**From:** Judith Ward  
**Sent:** 03 June 2020 16:10  
**To:** Linda Griffiths  
**Subject:** 20/01162/DISC OS Parcel 7400 Adj and S of Salt Way

Hi Linda

Drawing Title: **PRELIMINARY CUT & FILL ANALYSIS**

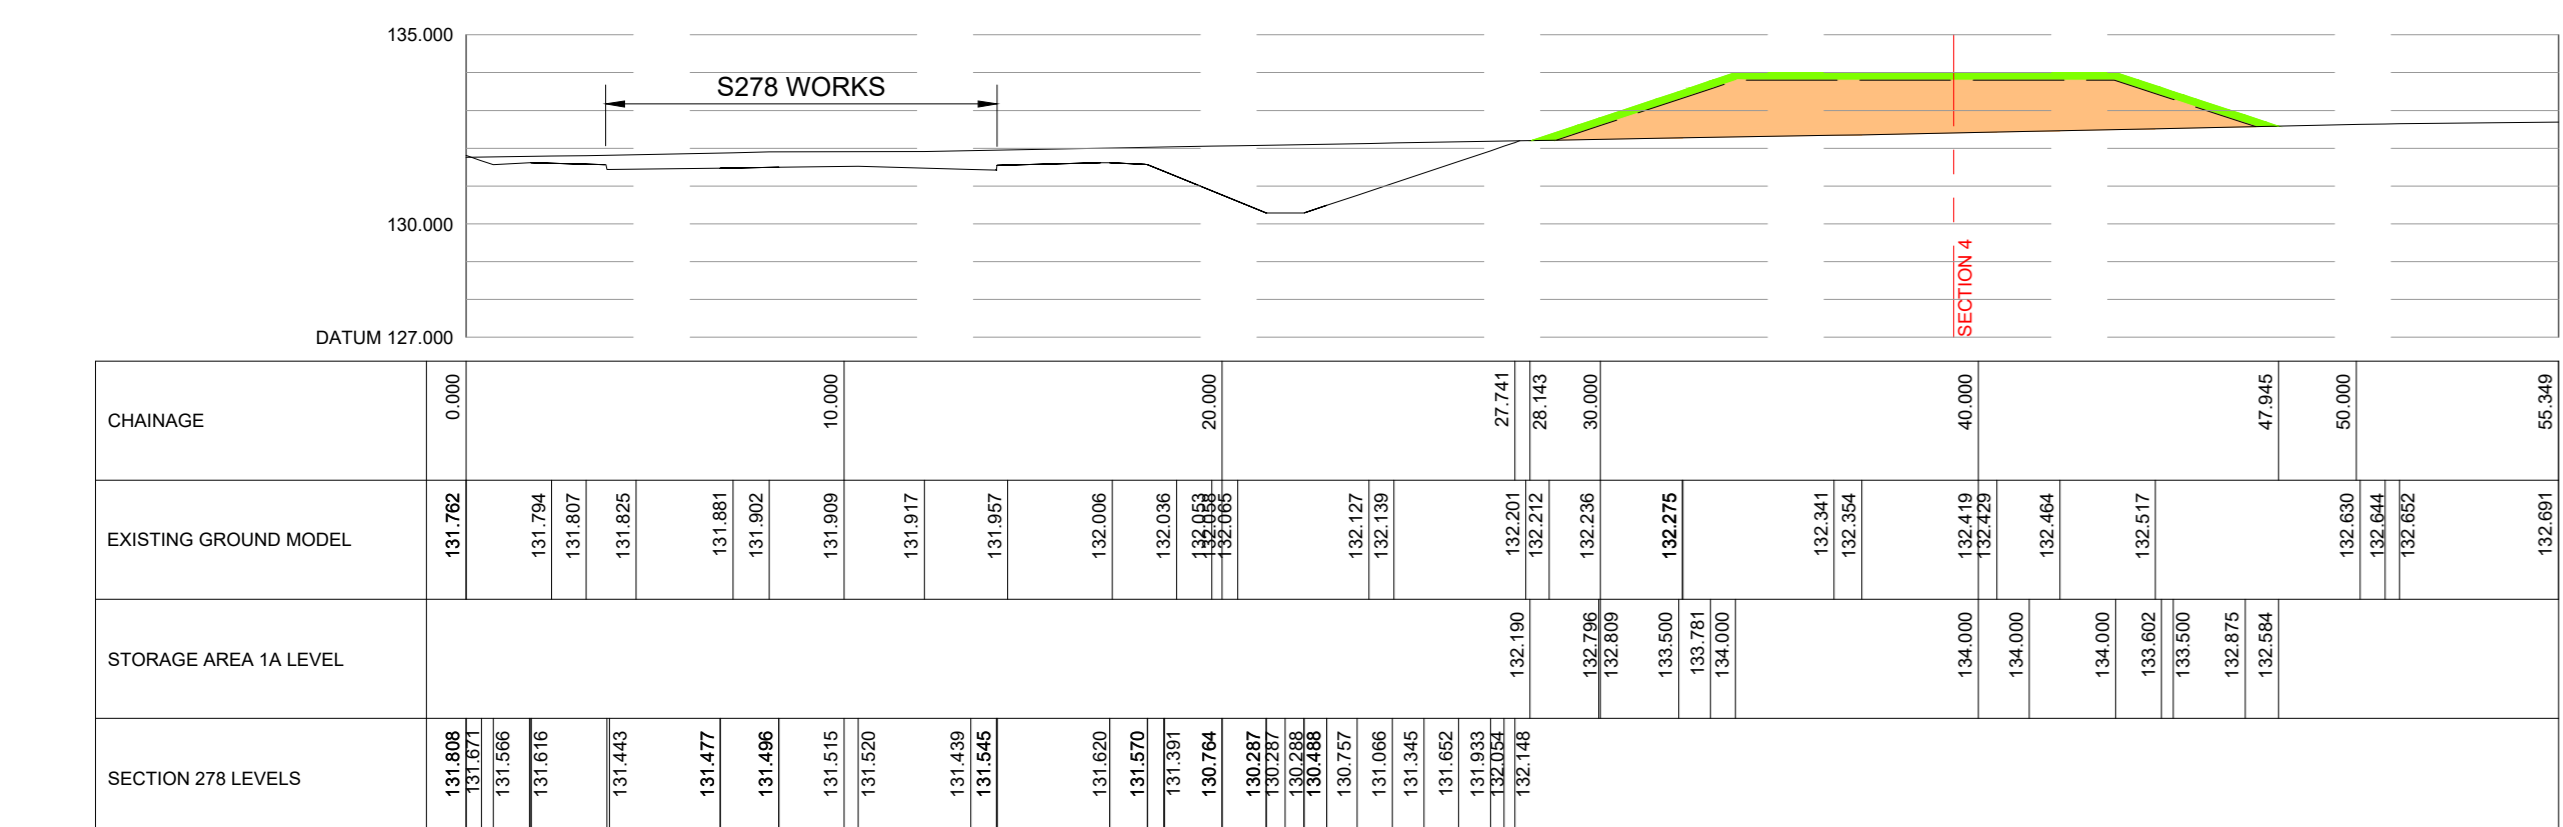
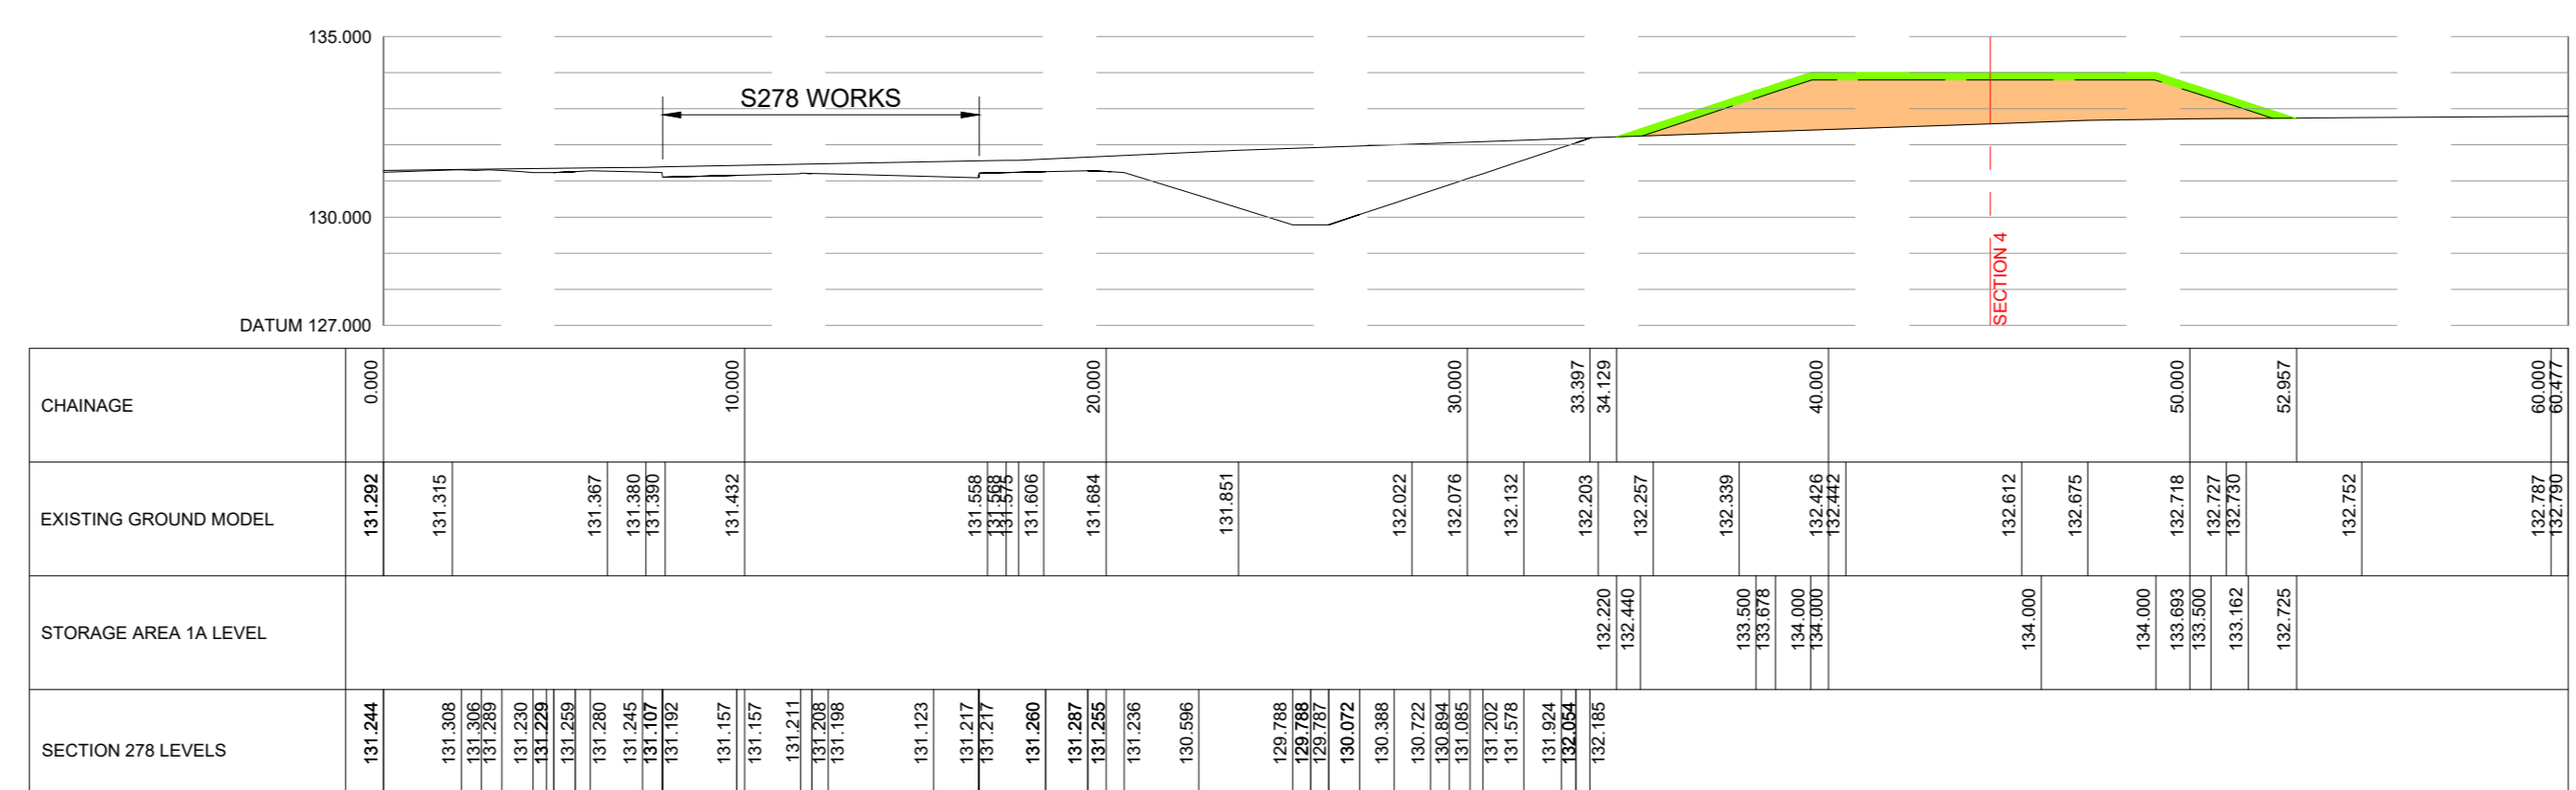
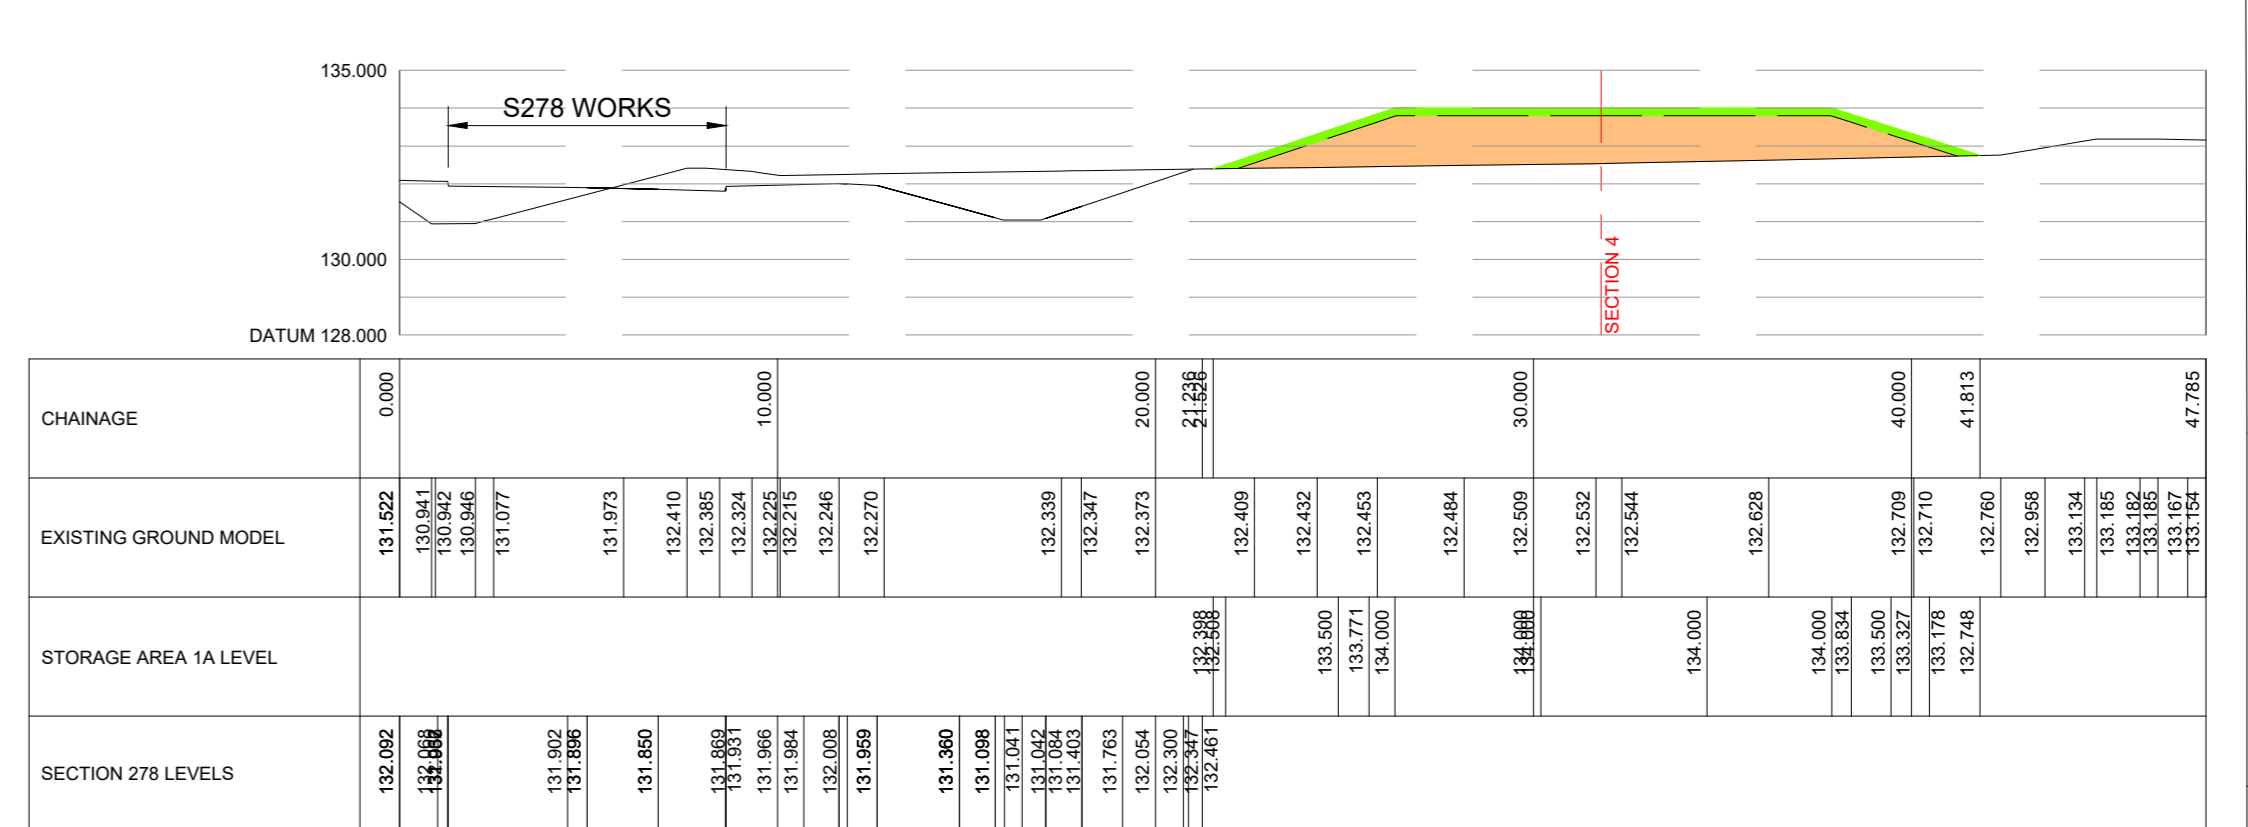
I would like to see confirmation that the earthworks strategy will achieve a cut and fill balance not just an intention. We don't want to be faced with the need for additional mounds at a later stage as on Bankside. This needs to be resolved now.

Can they confirm that all the spoil generation from housebuilding has been calculated and accounted for? 1.2.1 seems to suggest it hasn't.
